The Five Village Society

29th January 2018

Ref : Y/92/170UT - Land at Drove Lane, Yapton - 300 units
=====

FIGURE 14. Conservation Area and Listed Buildings in Yapton

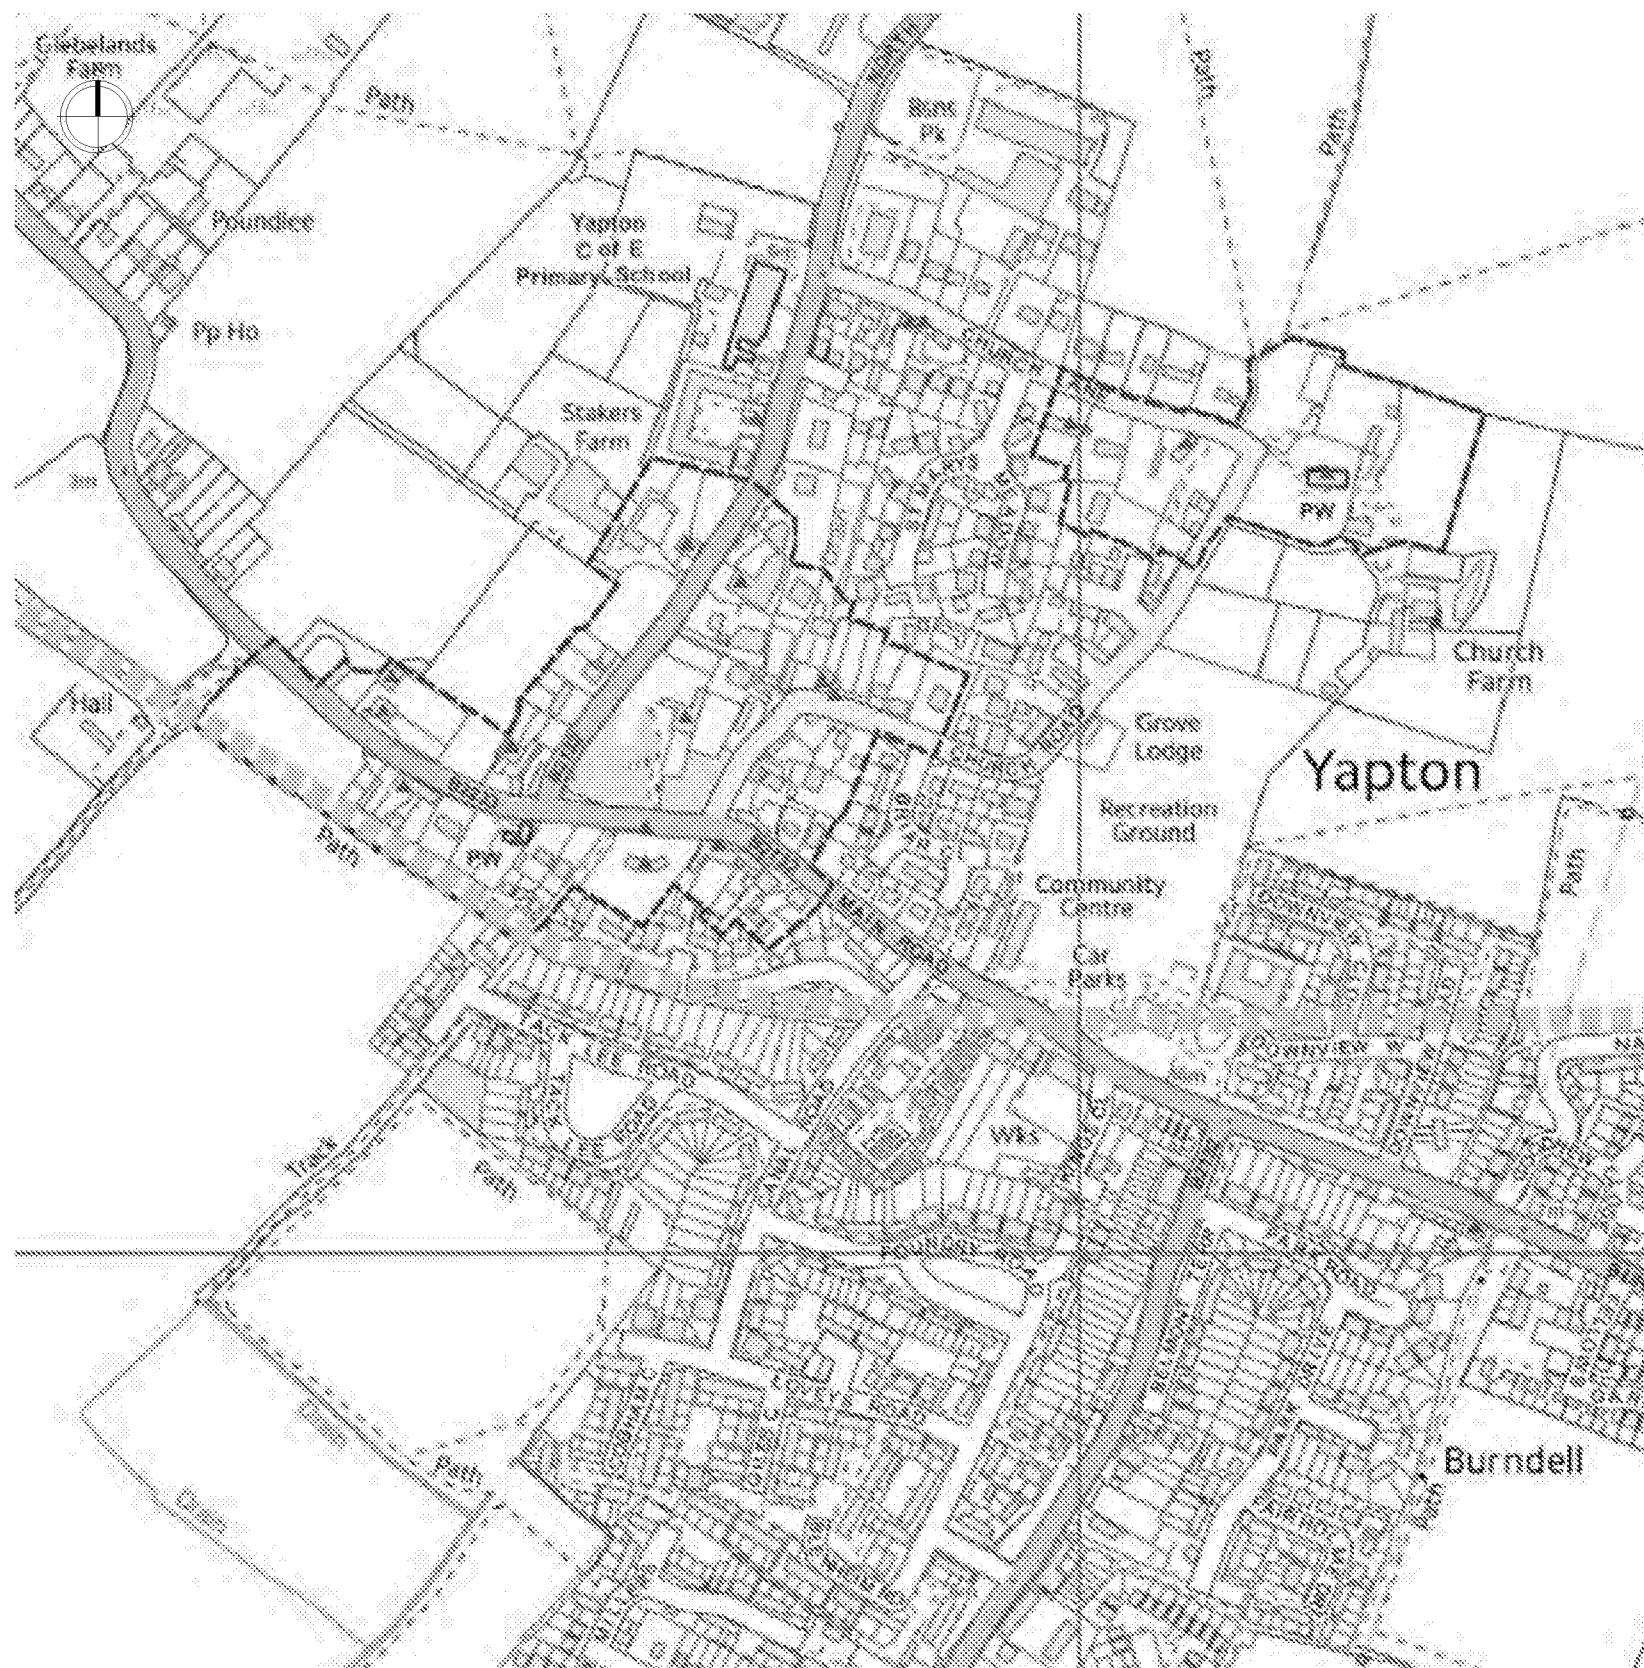
1. Education provision - both primary and secondary.
2. Housing mix to provide for single occupancy - young, elderly and disabled.
3. High density does not allow for adequate open space.
4. Traffic management - just one exit onto Main Road, near the recently approved Bonham's Field development and sharp bend. This will need a roundabout to ensure safety of joining vehicles.
5. Sewage and drainage management are a cause for concern.
6. Estate roads poorly designed and will not allow easy access for large delivery vehicles, dustcarts and emergency vehicles.
7. No scheduled bus service to reach Barnham mainline station.
8. The Conservation Area and Listed Buildings are not clearly identified. Nor is the line of the Canal.
